Traffic Solutions
William J. Bray, P.E.
235 Bancroft Street
Portland, ME 04102
(207) 774-3603
(207) 400-6890 mobile
trafficsolutions@maine.rr.com

March 19, 2017

RE: Baxter Academy for Technology and Science – Response to Traffic Comments

DEMOLITION PLAN
OF:
185 LANCASTER STREET
PORTLAND, MAINE
FOR:
BOULOS ASSET MANAGEMENT
ONE CANAL PLAZA
PORTLAND, MAINE 04101

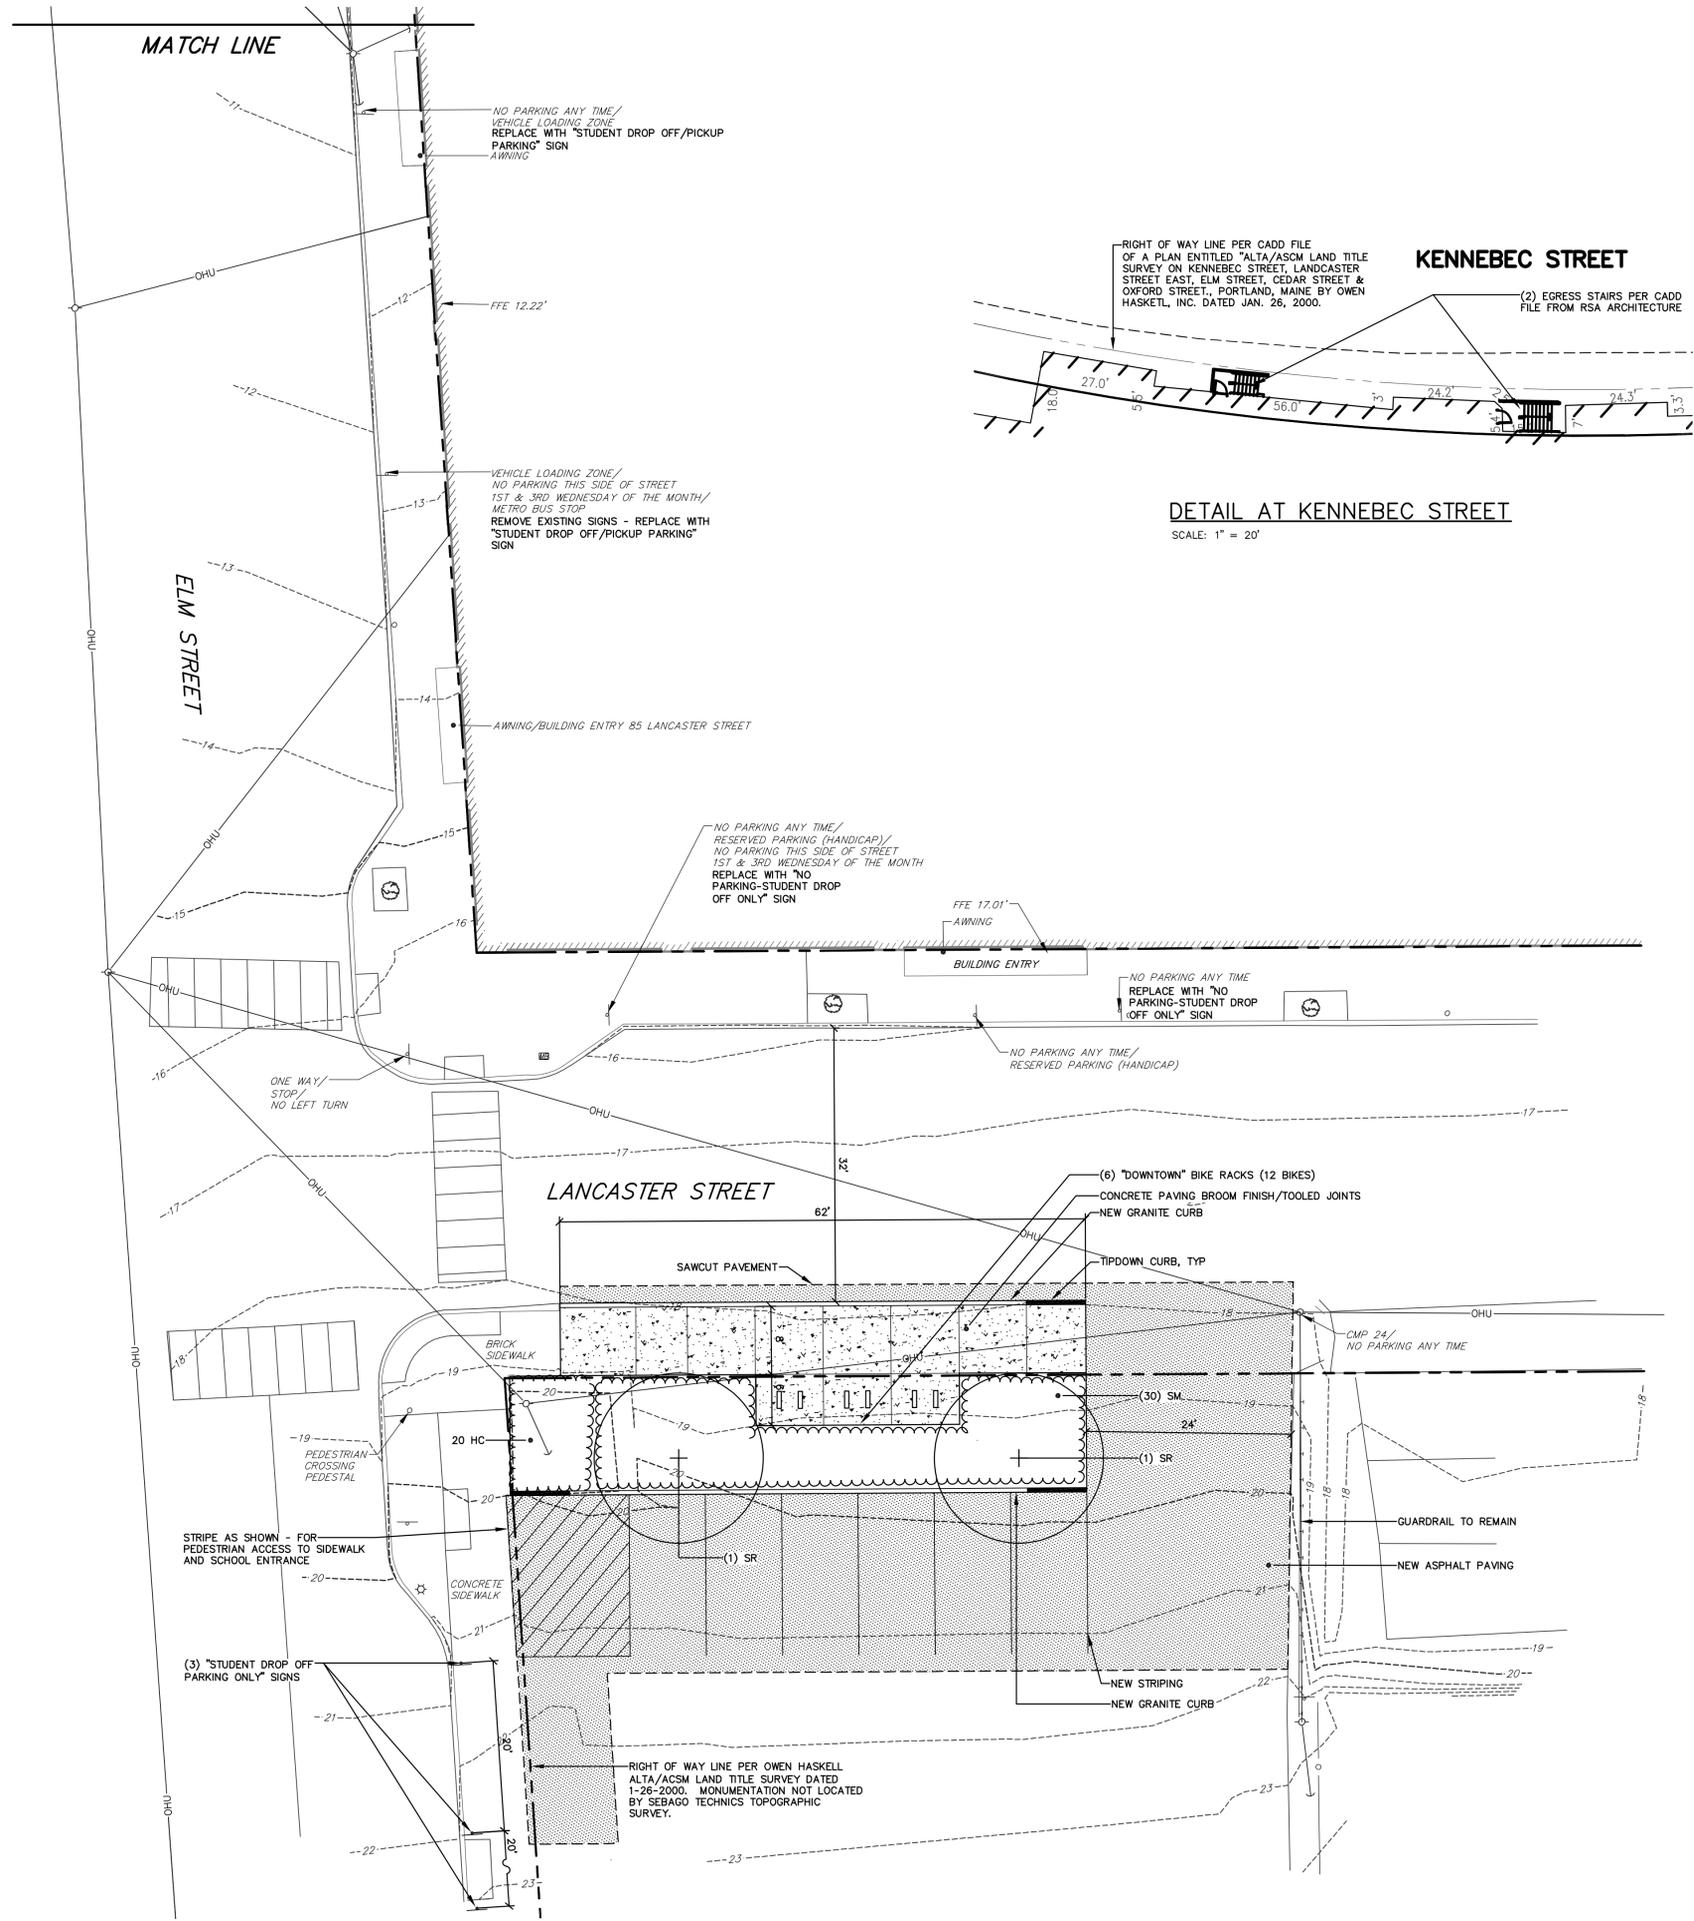
- The Lancaster Street improvement plan has been revised eliminating the prior parking bay design concept and replacing with an alignment following the existing edge of pavement.
